Recommendation Report for Listed Building Consent for Alterations, Extension or Demolition of a
Listed Building

REF NO: LU/62/21/L

LOCATION: 13 South Terrace
Littlehampton
BN17 5NZ

PROPOSAL: Listed building consent for works to renew mortar flashing with lead flashing, re-point to brick work & repair cornice/dental course to front, replace 3 No windows to top floor, repair & refurbish 9 No. wooden sash windows, replace canopy & refurbish/repaint balcony, repair & refurbish 2 No. set of wooden balcony doors, replace skirting board in lower ground floor, render & repair to front brick & rear flint walls,
refurbish/repaint front door entrances to lower ground floor, repair front brickwork, re plaster & paint front entrance & hallway, remove toilet front utility room on lower ground floor & re-tile top floor bathroom & add shower unit, reform lower ground floor steps & refurbish & repaint both front door entrances on lower ground & ground floor.

13 South Terrace Floor 2

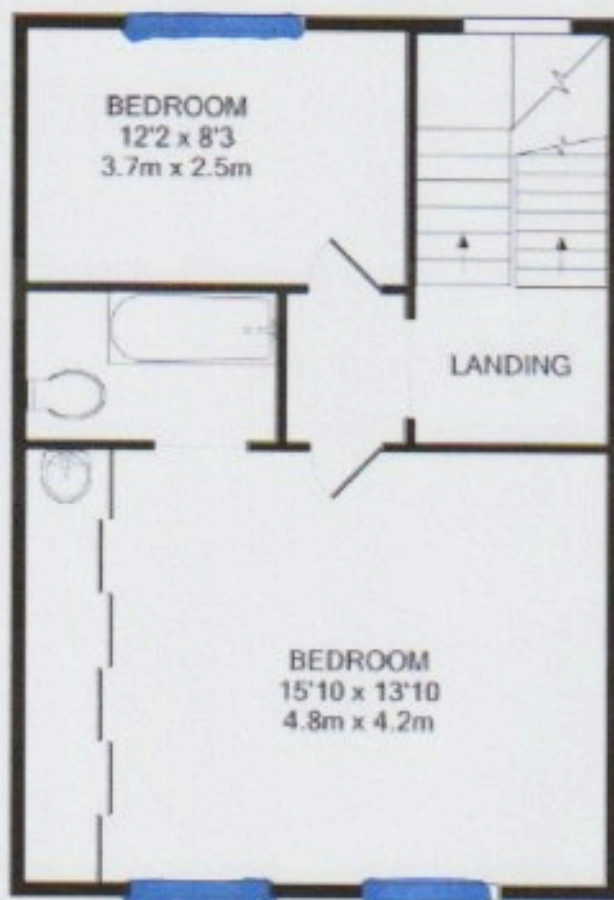
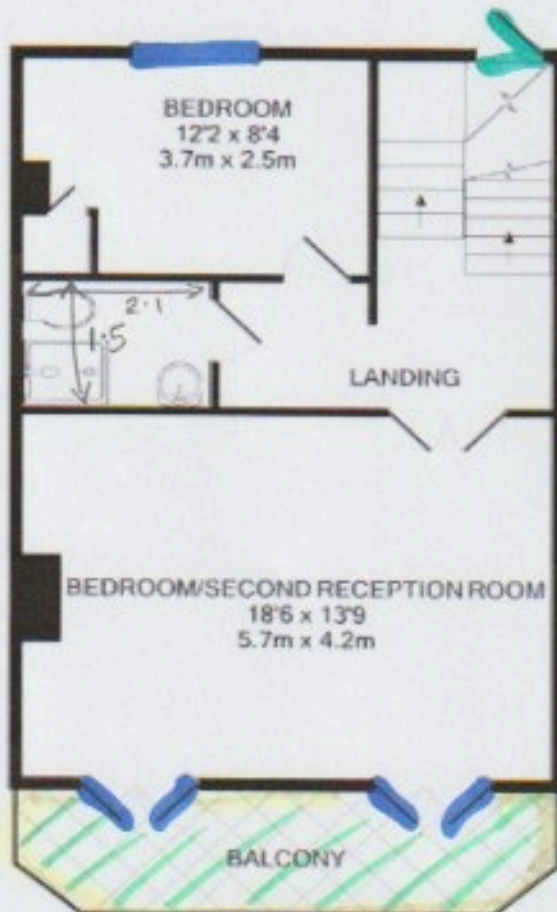
- 2 Prior to installation of the 3 top floor timber windows precise details of the glazing and frames including cross sections shall be submitted to and approved by the Local Planning Authority and the development shall proceed in accordance with the window details so approved.

13 South Terrace Gound Floor

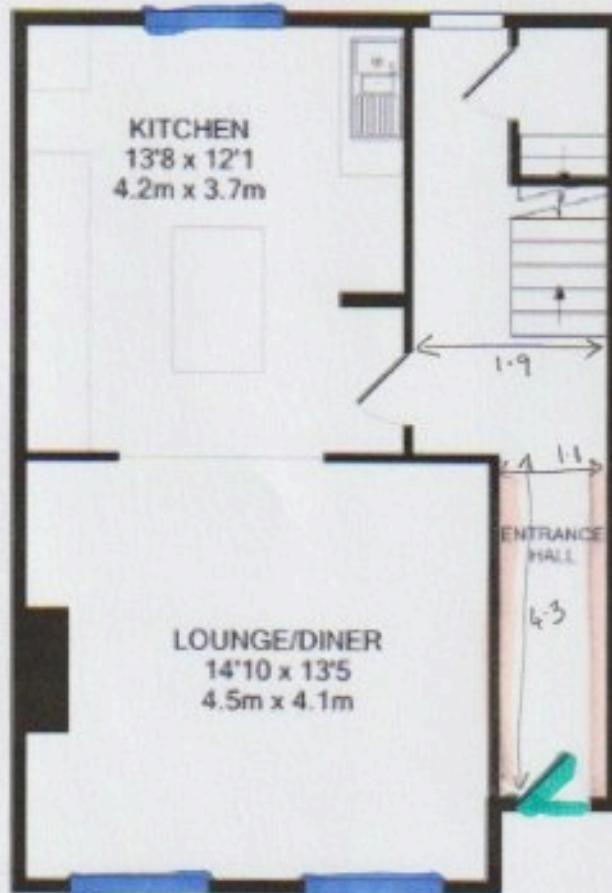
- 3 Prior to repainting of both front door entrances on lower ground & ground floor installation precise details of the paint colour shall be submitted to and approved by the Local Planning Authority and the development shall proceed in accordance with the colour so approved.

- 4 Prior to repainting of the front entrance & hallway precise details of the paint colour shall be submitted to and approved by the Local Planning Authority and the development shall proceed in accordance with the colour(s) so approved.

13 South Terrace Lower Ground Floor

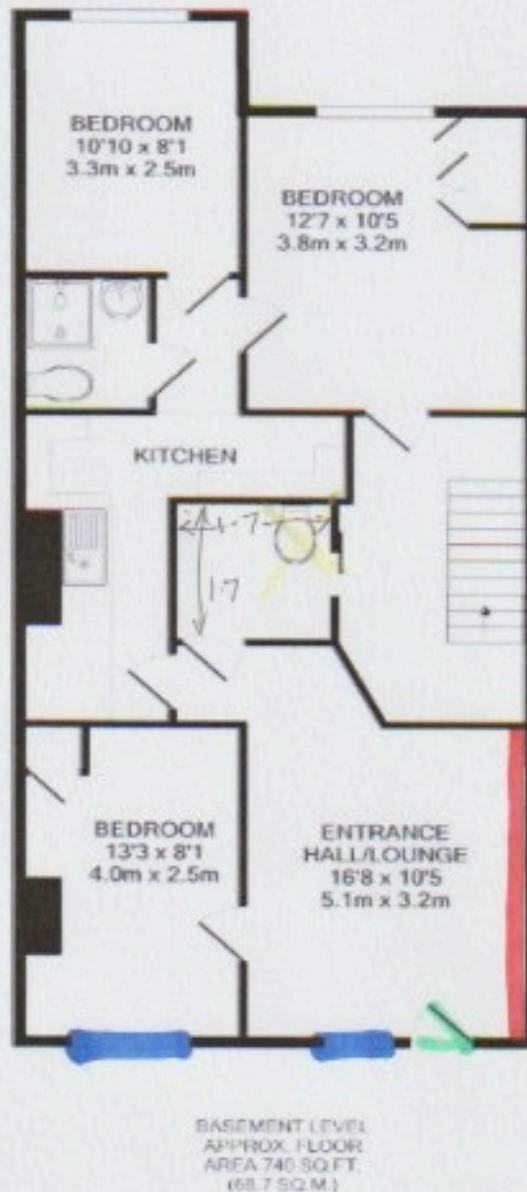
- 5 Prior to any works to reform the lower ground floor steps being undertaken precise details of the profile, materials and methodology shall be submitted to and approved by the Local Planning Authority and the development shall proceed in accordance with the details so approved.
